Subject: FW: A/109/20/RES Land South of Water Lane Angmering Approval of reserved matters following A/99/17/OUT

Subject: A/109/20/RES Land South of Water Lane Angmering Approval of reserved matters following A/99/17/OUT

With regard to Planning Application A/109/20/RES further information and correspondence has become available since I submitted my representation.

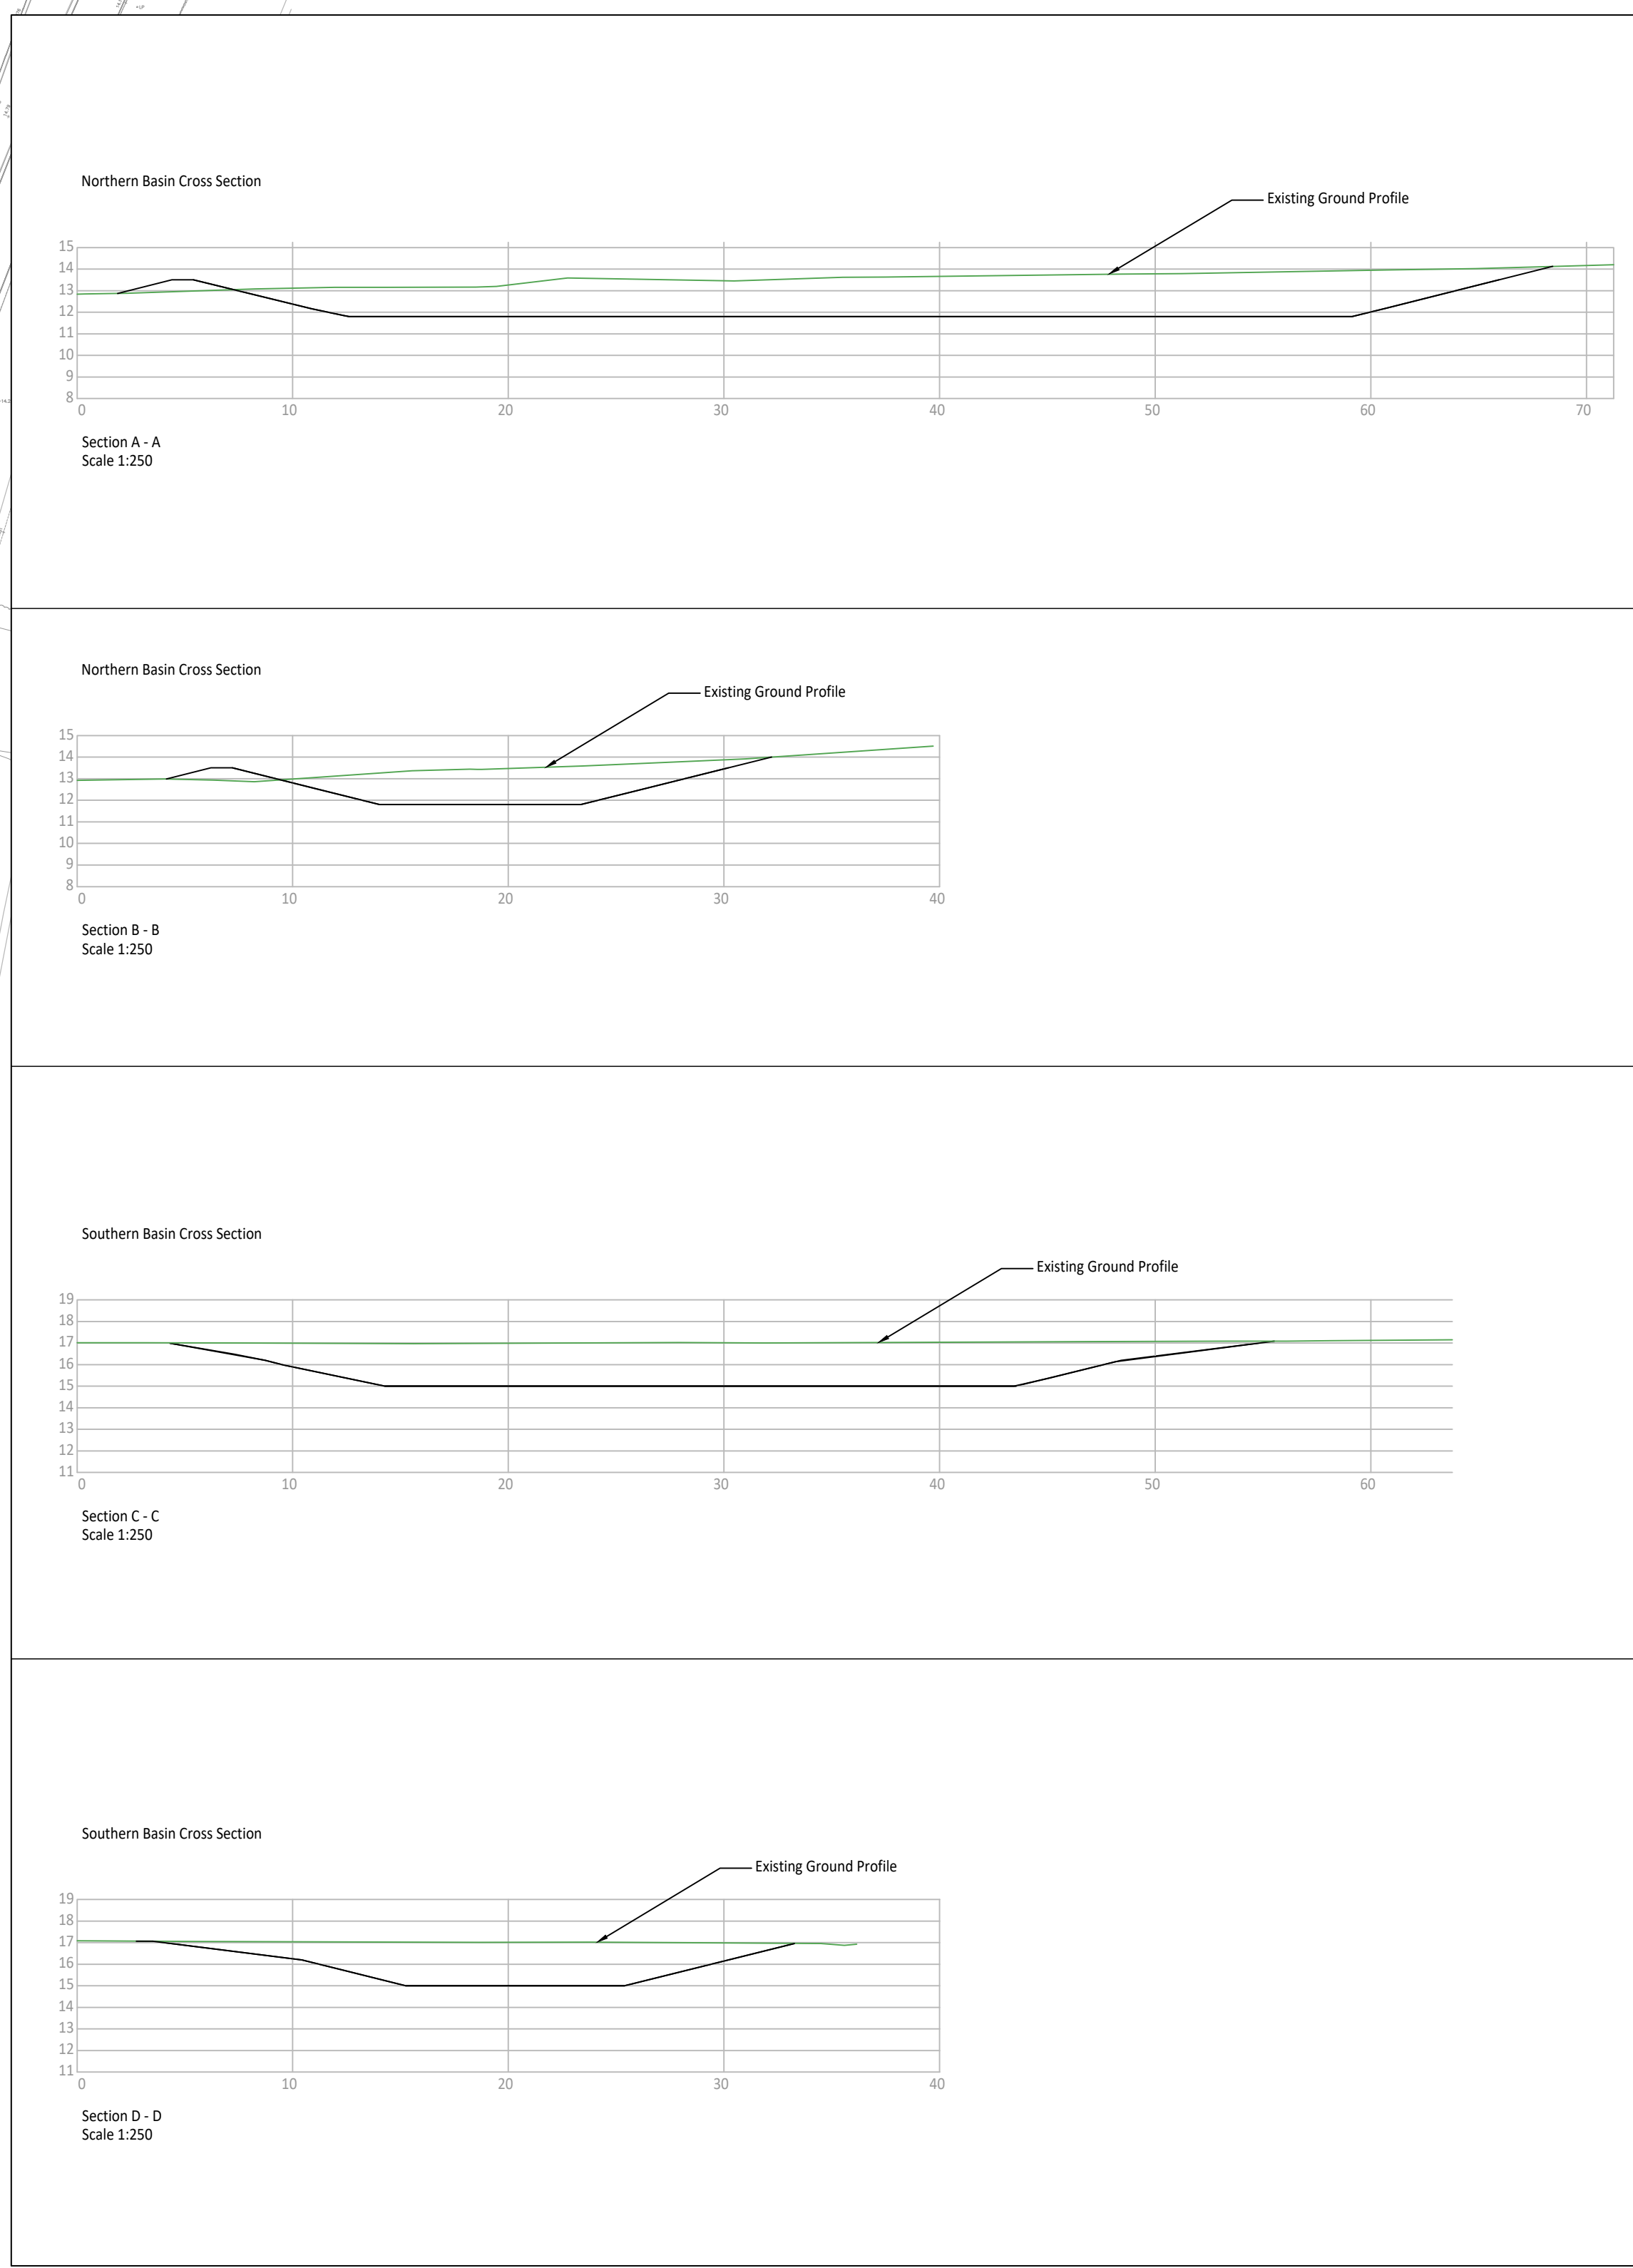
This area is extremely close to the southeast corner of the Application site. Surface water management of this overall Application site seems to be in three parts by area. It appears the proposal for the southeast corner of the site is to infiltrate surface water into the ground, via a pond. While the site investigation report appears to confirm this to be feasible I have often noticed the area to appear saturated.

I am anxious, as are others, that this development, and the associated drainage proposal should not exacerbate these, already identified, problems and, if possible, reduce them.

Arun District Council has an eminently sensible policy requiring an Applicant to submit 'Exceedance Flow Route Plans' for developments of more than five residential properties. The Applicant should provide these to offer some reassurance to those who live in the area to show where runoff will go if the infiltration pond is full.
